DEVELOPMENT REVIEW BOARD
TRANSPORTATION DEVELOPMENT

DRB Project Number: 1006602
Ventura Plaza

SUBJECT: Preliminary/ Final Plat, EPC Approved Site Plan for Building Permit, Amended Site Plan for Subdivision

DRB Project Number: 1006602 Hearing Date: 03-14-2018
 Project: Ventura Plaza Lots A-2-A & A-2-B Agenda Item No: 6

Project Number 2017010
Drawn By OW
Checked JW
Issue Date March 5, 2018
Site Plan for Building Permit

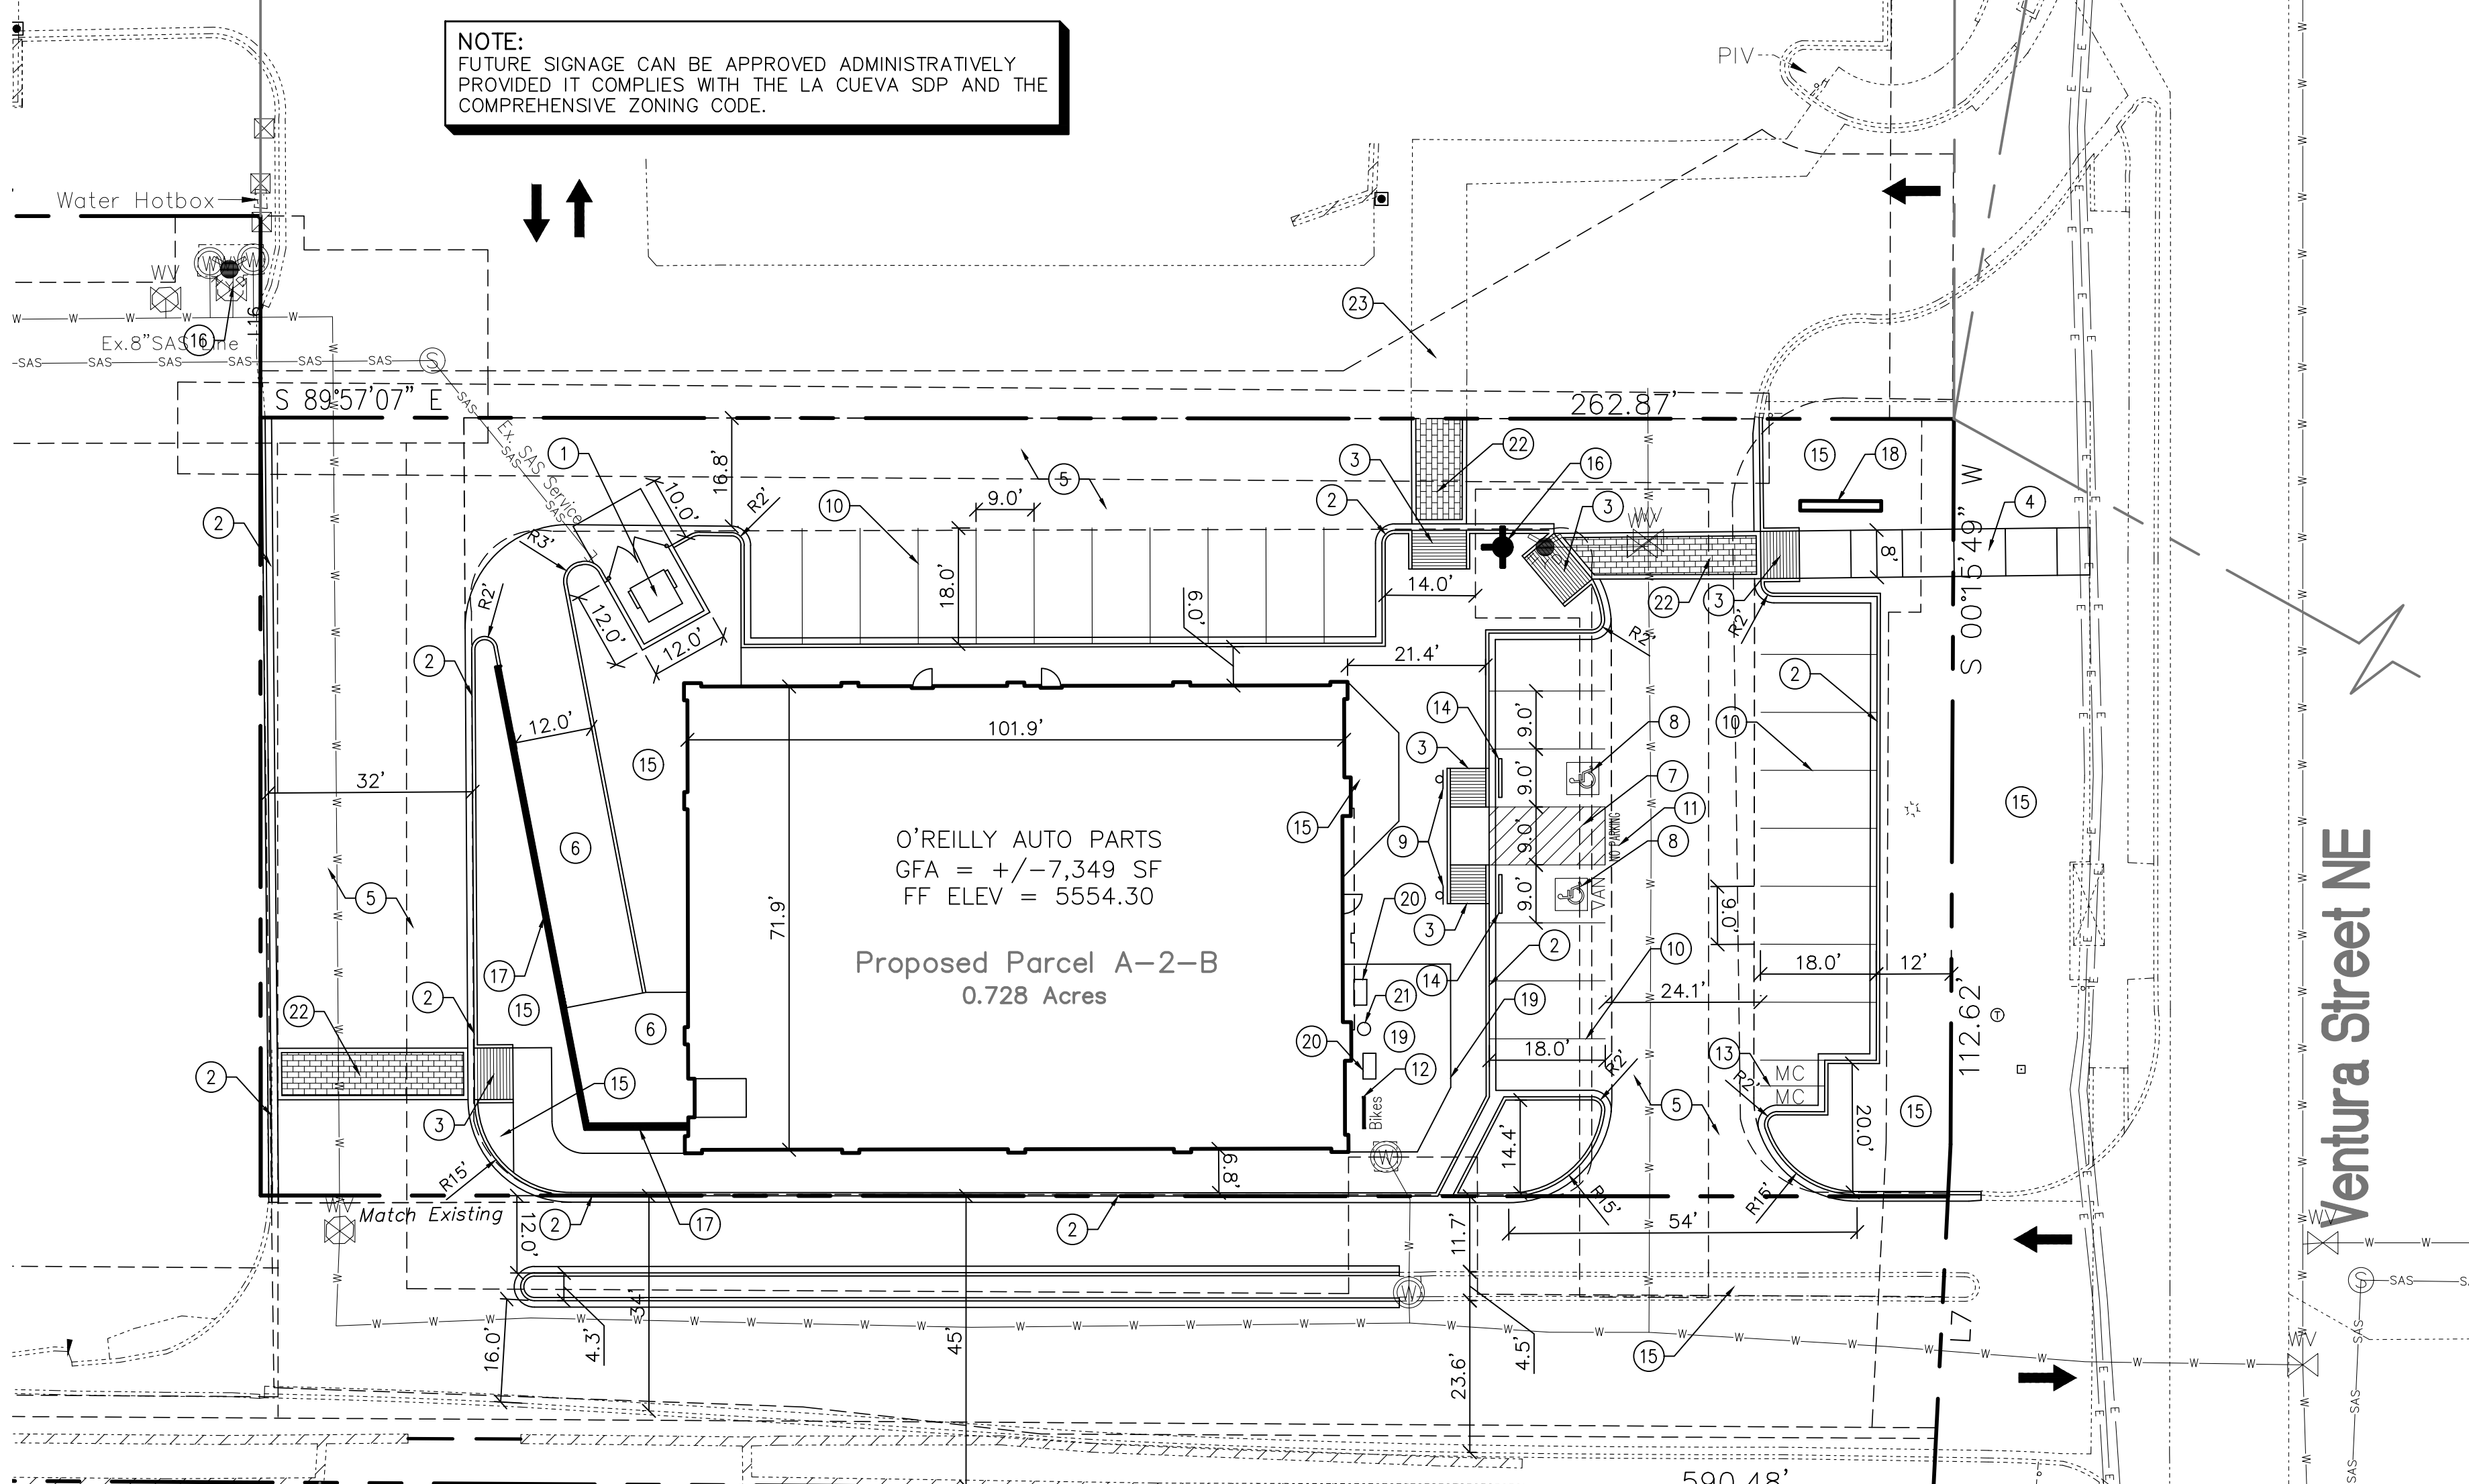
1. No objection to plat.
2. Motorcycle parking spaces shall be designated by its own conspicuously posted upright sign, either free-standing or wall mounted per the zoning code.
3. Remove the note "Not For Construction".
4. Please add a note on the plan stating "All improvements located in the Right of Way must be included on a public work order."
